Rezoning Transportation Analysis

Petition Number: 2023-124

Date	Description
11-21-23	First Review (IW)
12-19-23	Second Review (KC)

**RZ-1.0**

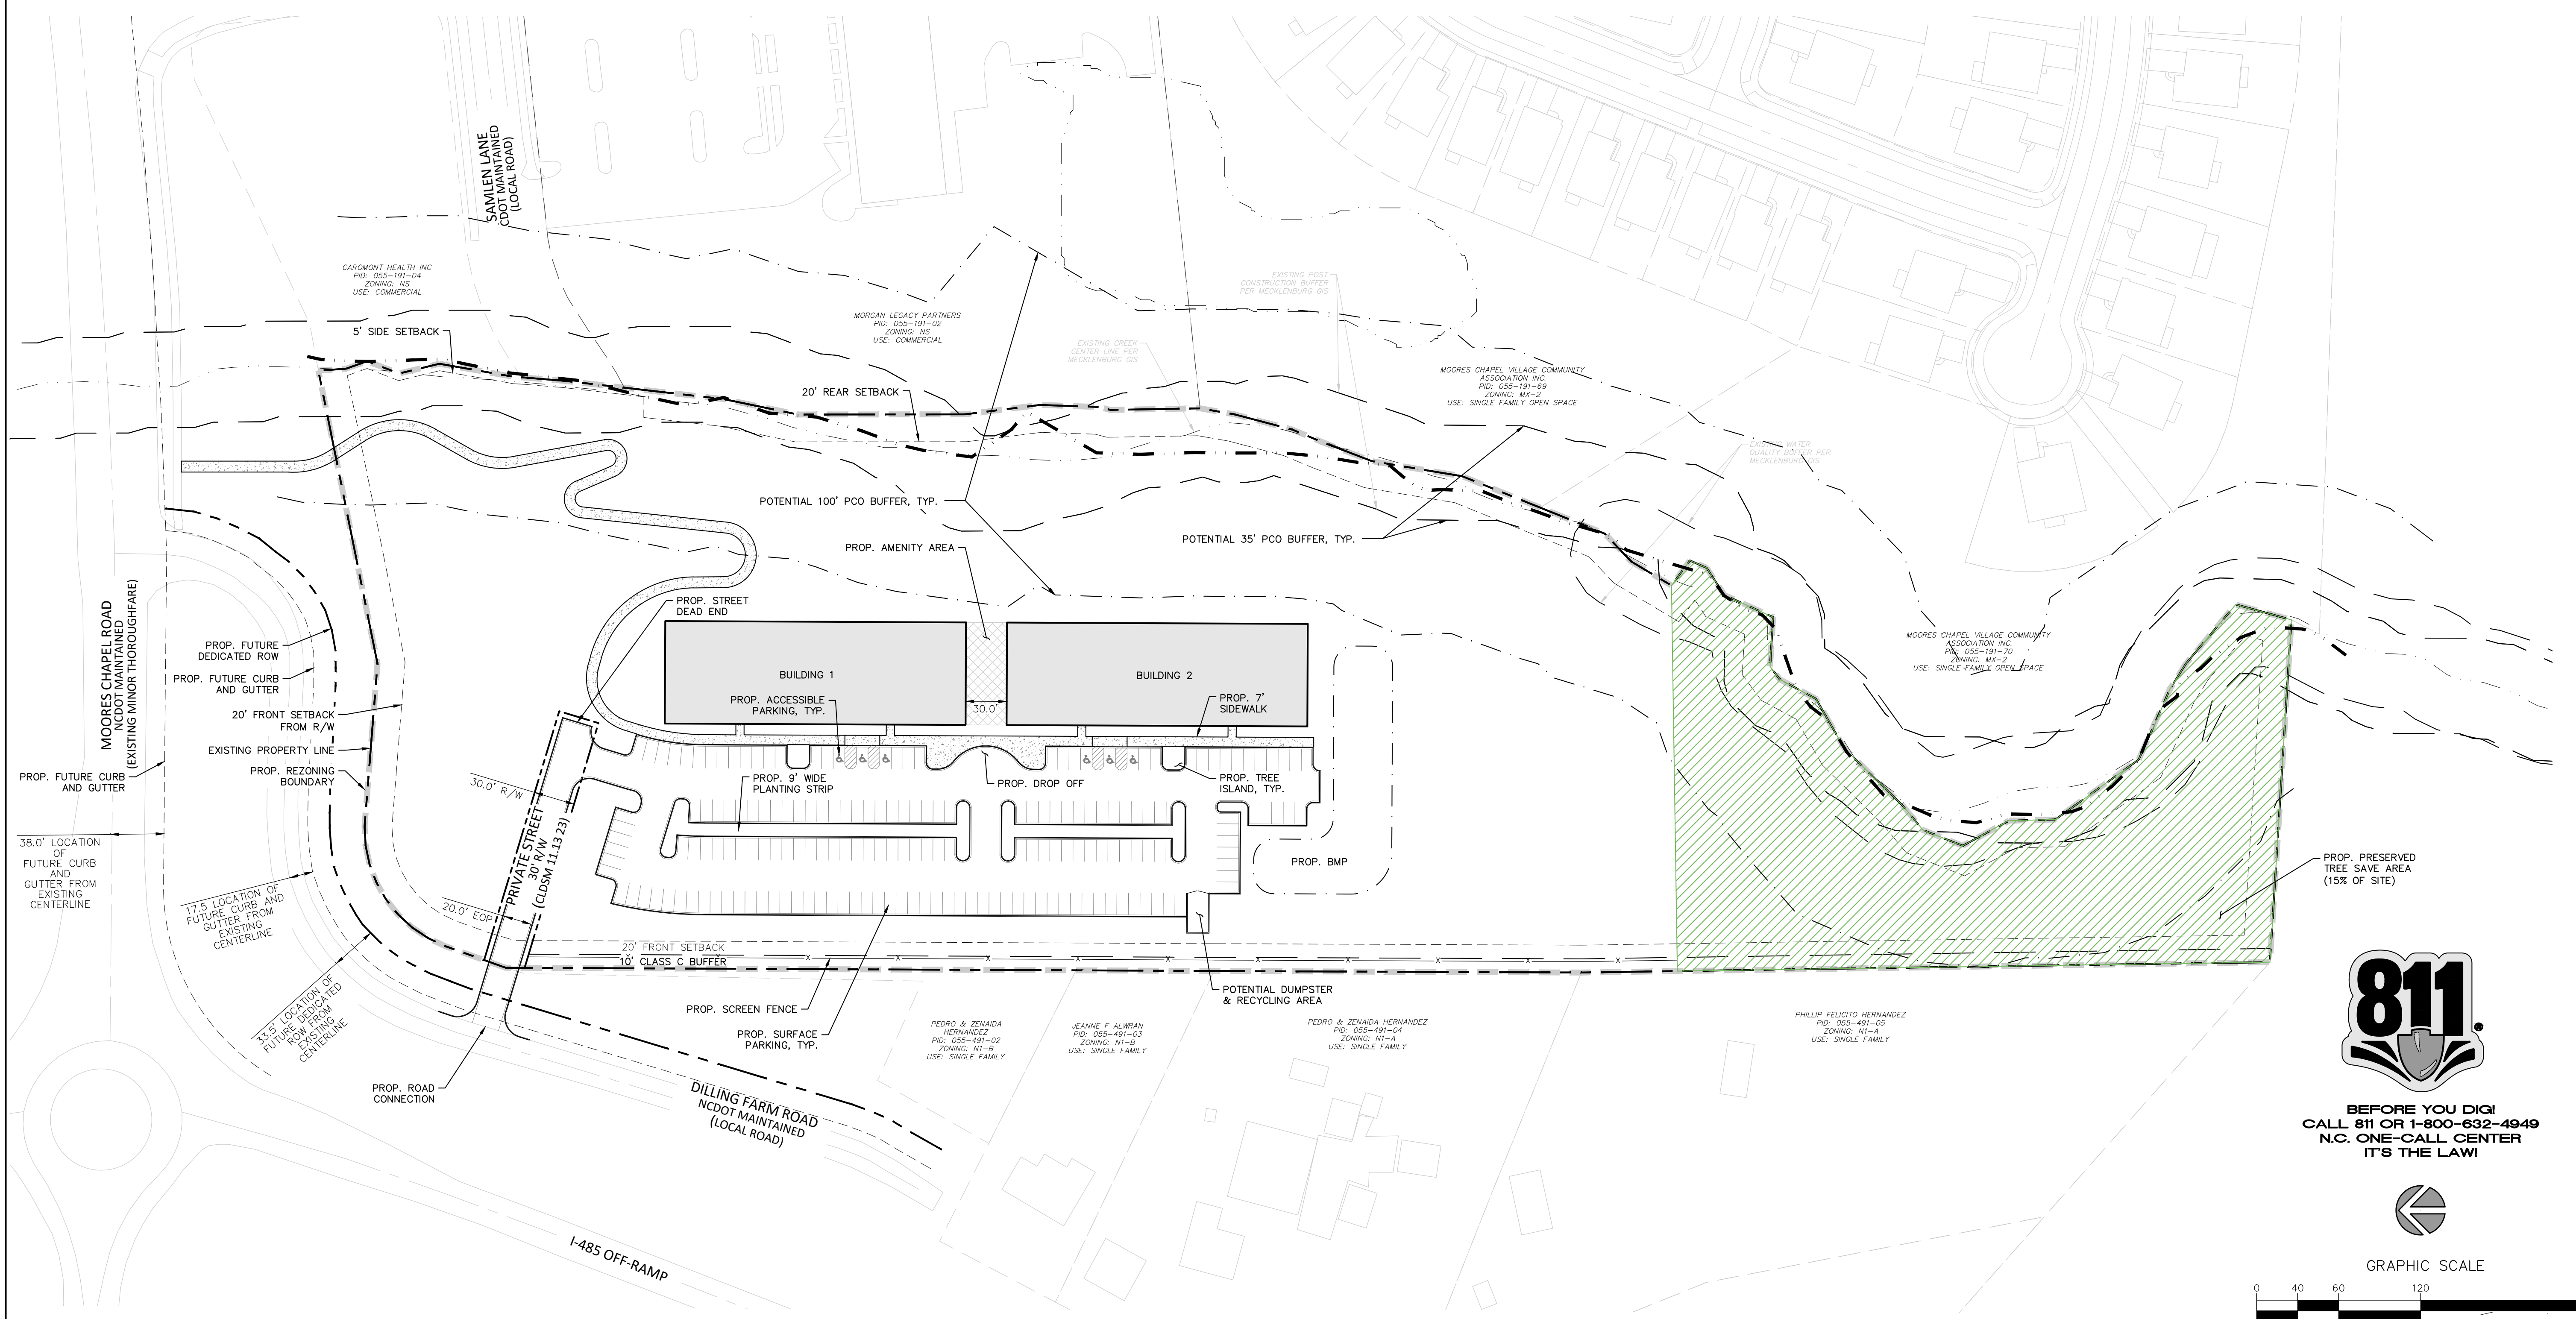
5. **Outstanding Comment 11-21-23:** Revise site plan and conditional note(s) to commit to constructing an 8' planting strip and an 8' sidewalk per Article 33 of the UDO and CLDSM U-03A1 along Dilling Farm Road.

Clarifying Comment: Site plan does not show 8' planting strip and an 8' sidewalk per Article 33 of the UDO and CLDSM U-03A1 along Dilling Farm Road.
